From: Lucy Ward [REDACTED]
Sent: 26 August 2021 15:01
To: Erika Davies
Cc: ENC PLANNING; William McCormack; Joshua Ingram
Subject: RE: NE/21/01283/FUL & NE/21/01284/LBC
Attachments: (08)005 Rev A - Proposed Ground Floor Plans.pdf; (08)007 Rev B - Proposed Elevations.pdf; DRAWING REGISTER.pdf

From: Erika Davies [REDACTED]
Sent: 26 August 2021 15:05
To: Lucy Ward [REDACTED]
Cc: ENC PLANNING <PLANNING.ENC@northnorthants.gov.uk>; William McCormack [REDACTED]
Subject: NE/21/01283/FUL & NE/21/01284/LBC

Firstly may I propose a change to the description of both applications to:
NE/21/01283/FUL "Replacement single storey rear extension and 2 porches; replacement outbuilding and erection of new detached garage / home office; alterations to the existing car parking provision and changes to landscape"
NE/21/01284/LBC "Replacement of single storey 1970s rear extension and 2 timber porches including associated Internal repairs and alterations to the cottage"

Drawing  
**PROPOSED Elevations**

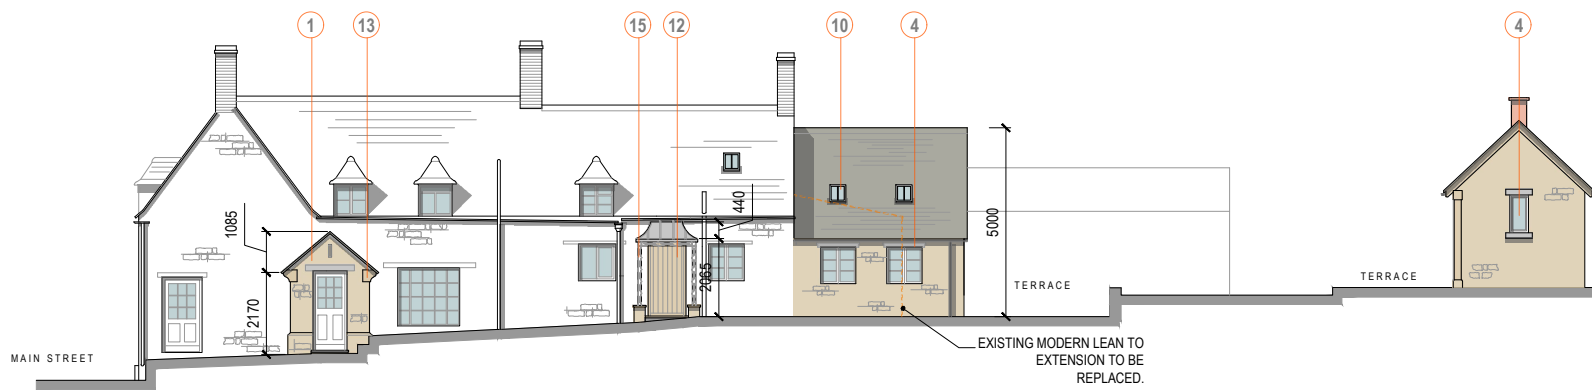
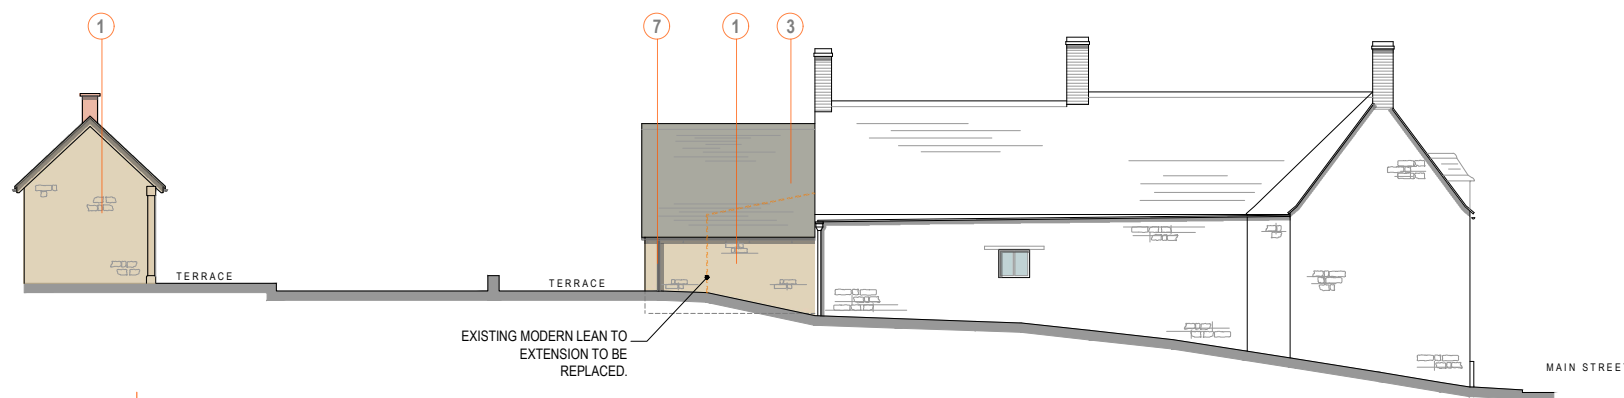
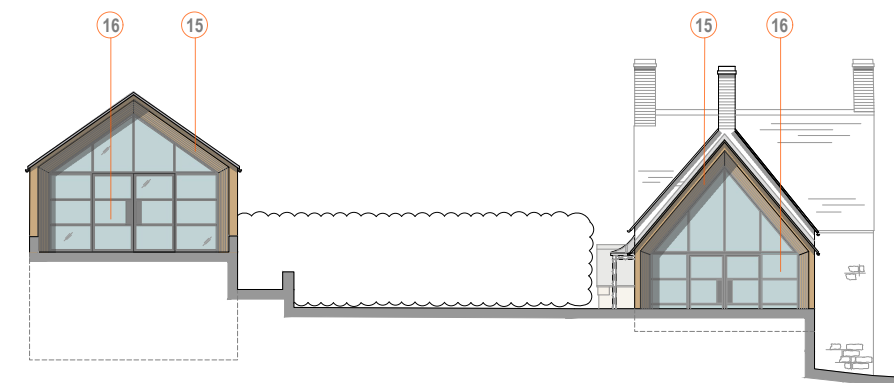
Lastly, the dimensions for the proposed porches have not been provided. Please provide amended proposed floor plans and elevations showing the proposed floor plan and elevational dimensions for the replacement porches.

We agree to your proposed description of the applications. Please also find attached the revised ground floor and house elevations, as well as the revised document issue sheet, showing the dimensions of the proposed porches.
